Initial engineers comments:

<div>REDWOOD</div>	
CLIENT: Chanel	
PROJECT: New Bond Street	
VENUE: London	
DATES: NA	
TITLE: Notes	
DRAWN BY: DH	
DRAWING DATE: 09-08-2021	
REVISION: 1	
All construction, materials, electrics and services to comply with local authority, organiser, hall, health, fire and safety regulations.	
No amendments, substitute materials and/or fittings to be used without the prior approval of End Client	
UNLESS OTHERWISE SPECIFIED DIMENSIONS ARE IN MILLIMETERS	
SHEET 10 OF 10	A1

Building showing fixings

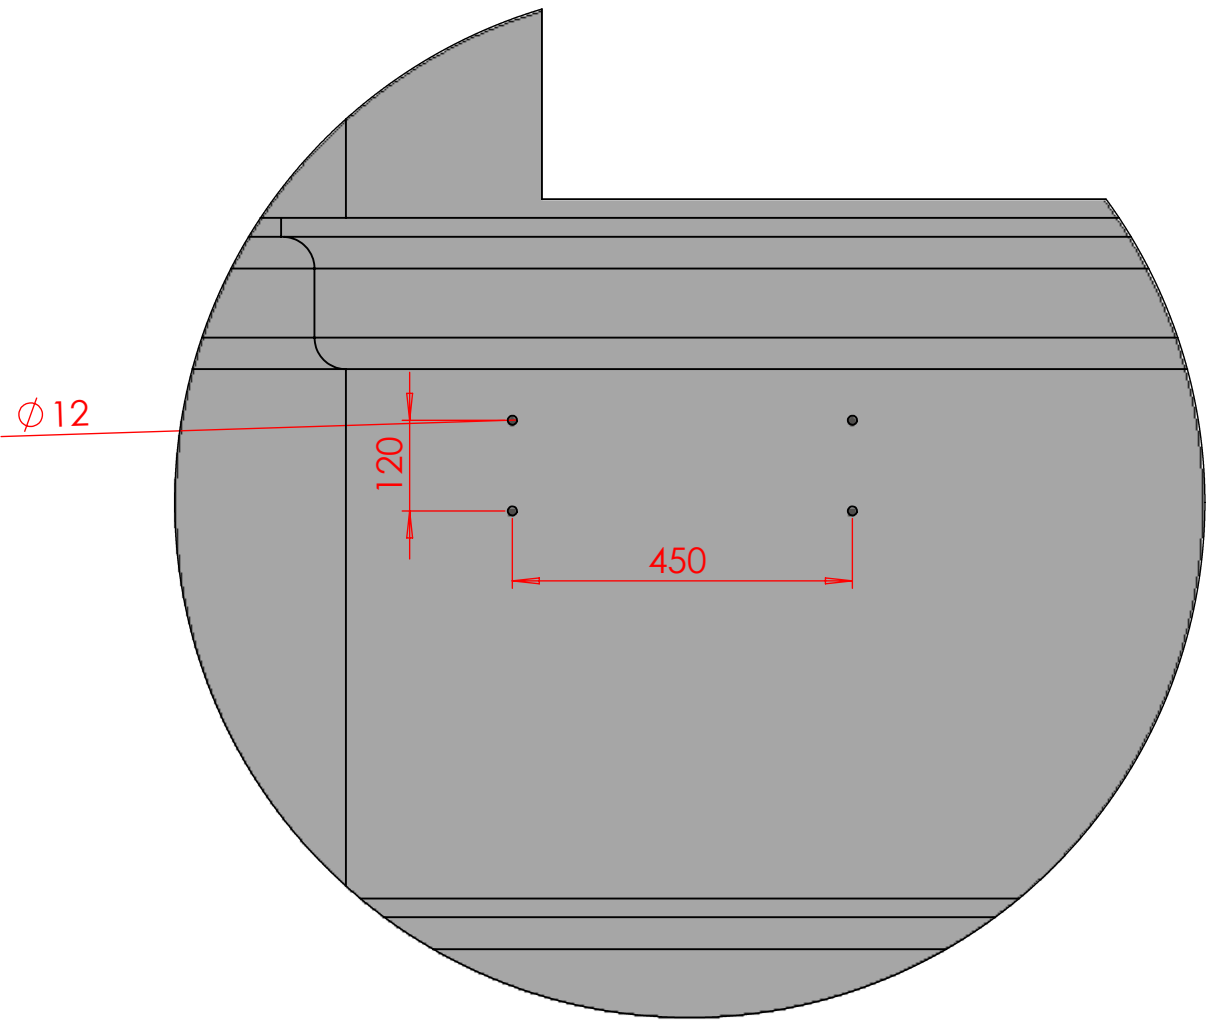
All chemical fix studding is normally tested to
1.5t. Architect to confirm building will be ok.

28 Points in total.

Proposed Truss Design

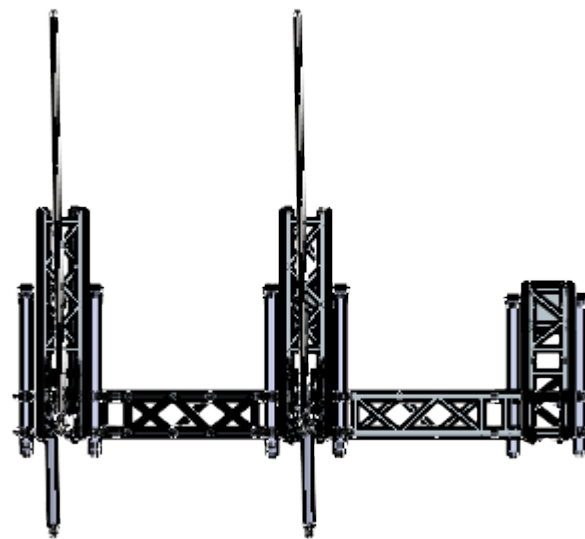
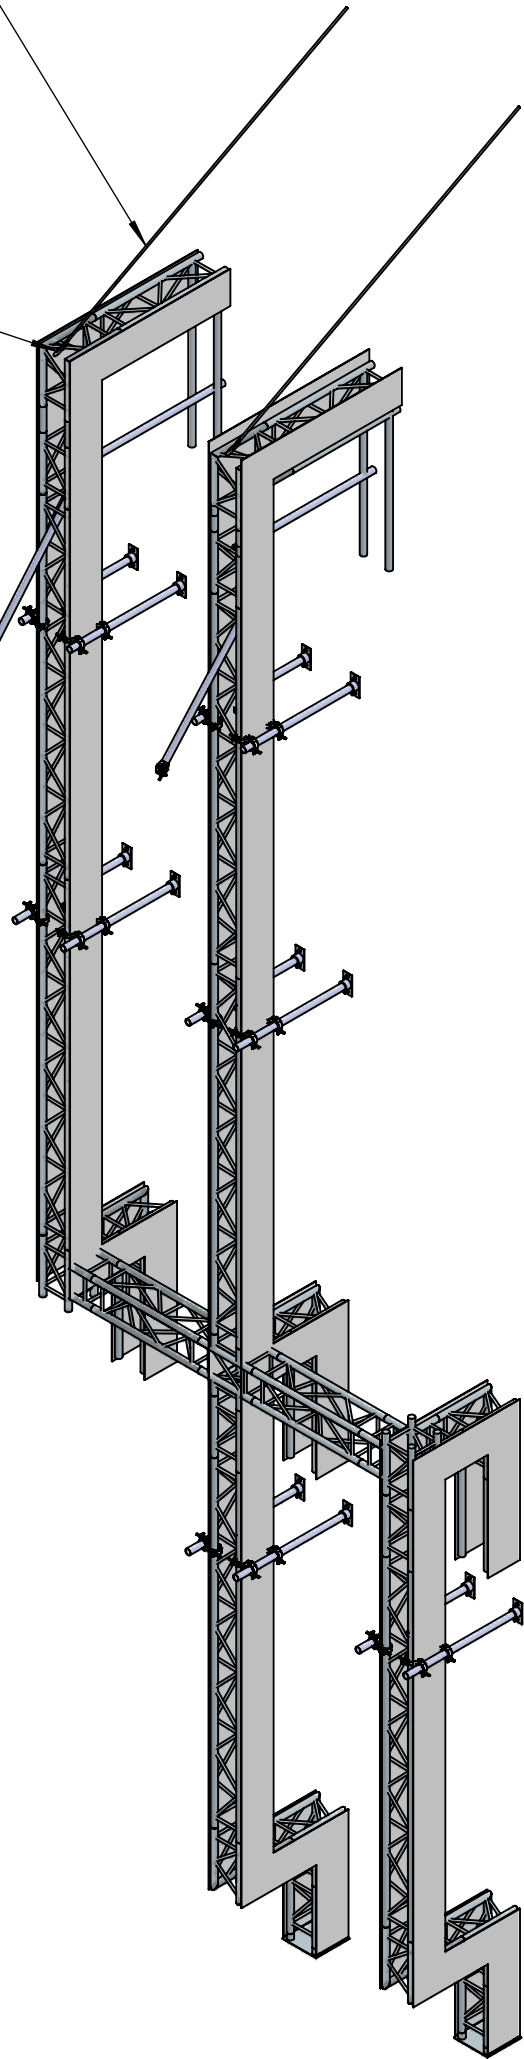
Security cable to top of truss and building:

12mm eyelet chem fixed in 80mm - 90mm.
Cosby shackle 1.5t.
Rutlinger 5mm.
SWR 5mm galvanised.

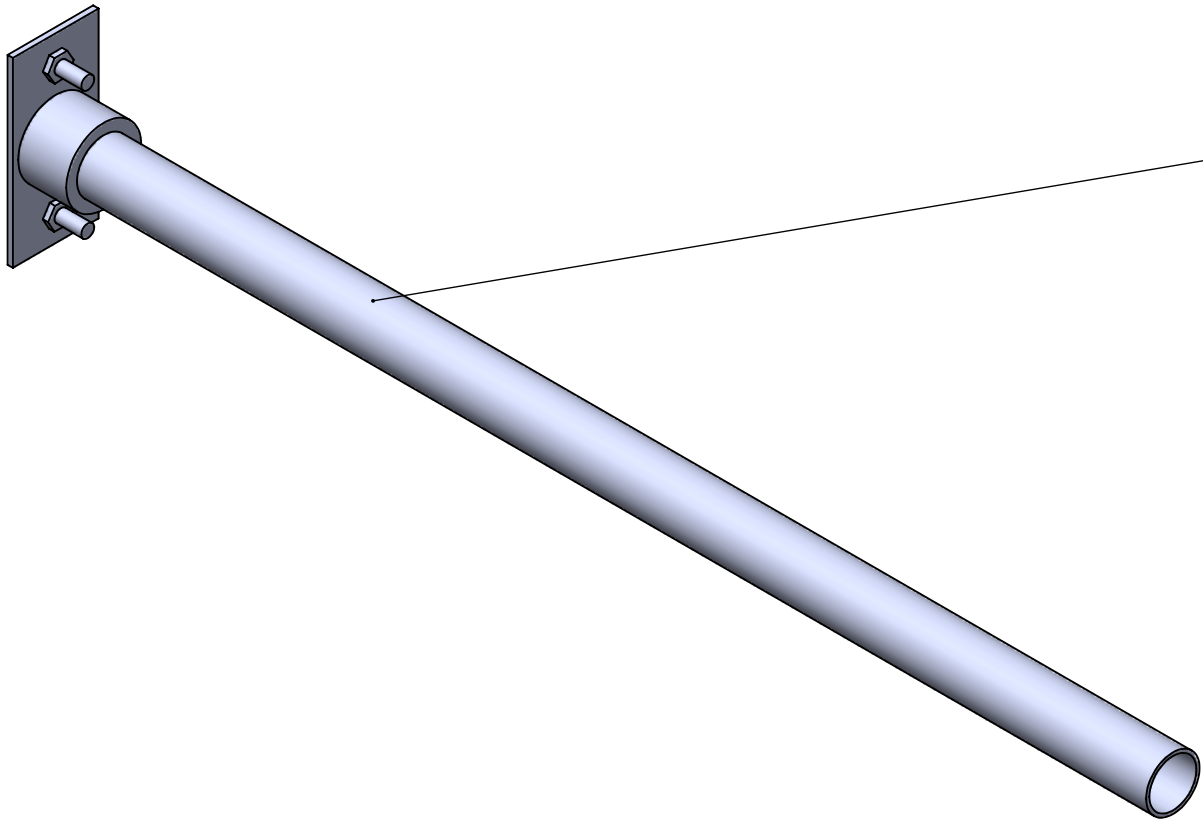
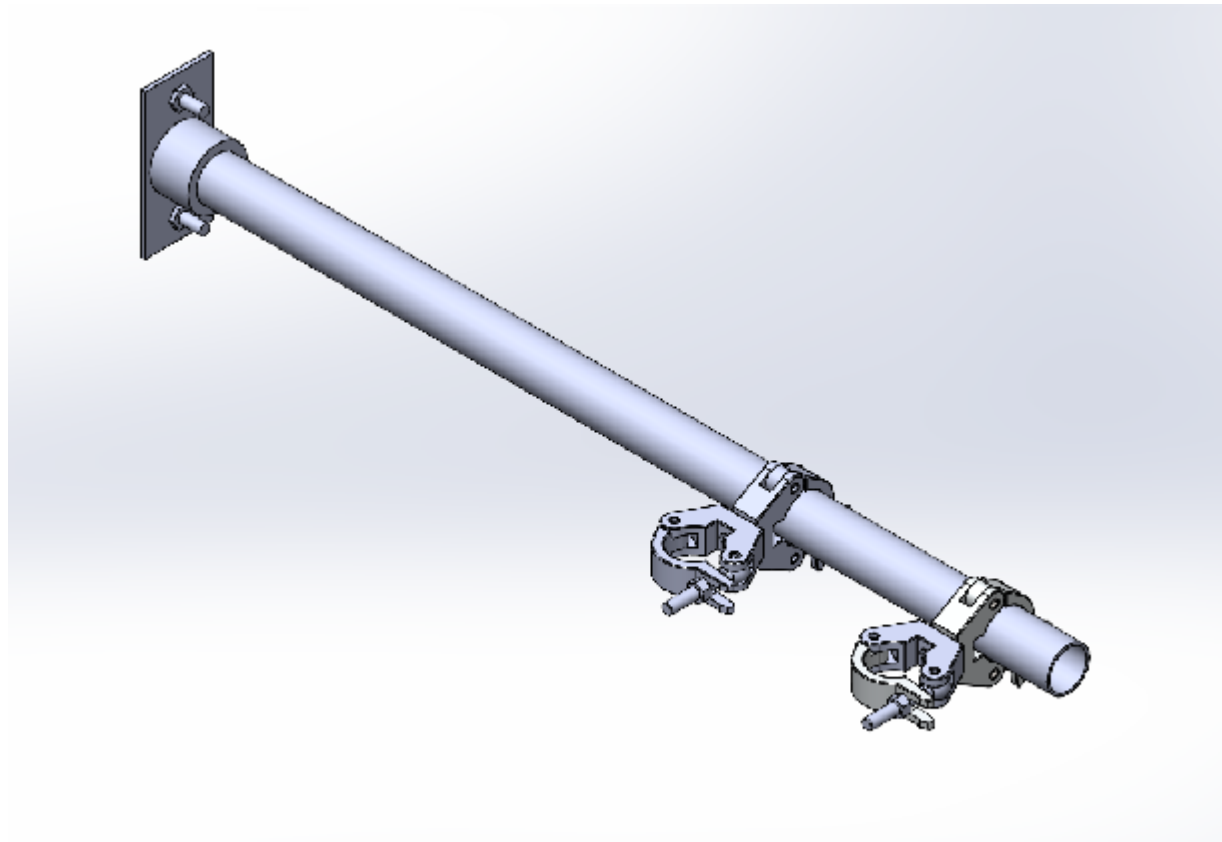
Brackets fixing truss to building:

Steel Keyclamp base welded onto steel
50mm scaffold tube.

12mm stainless steel studding 80mm
to 100mm chemical fixed into wall.

50mm protruding from bracket washers
castle security nut and secondary
nylock all BZP.
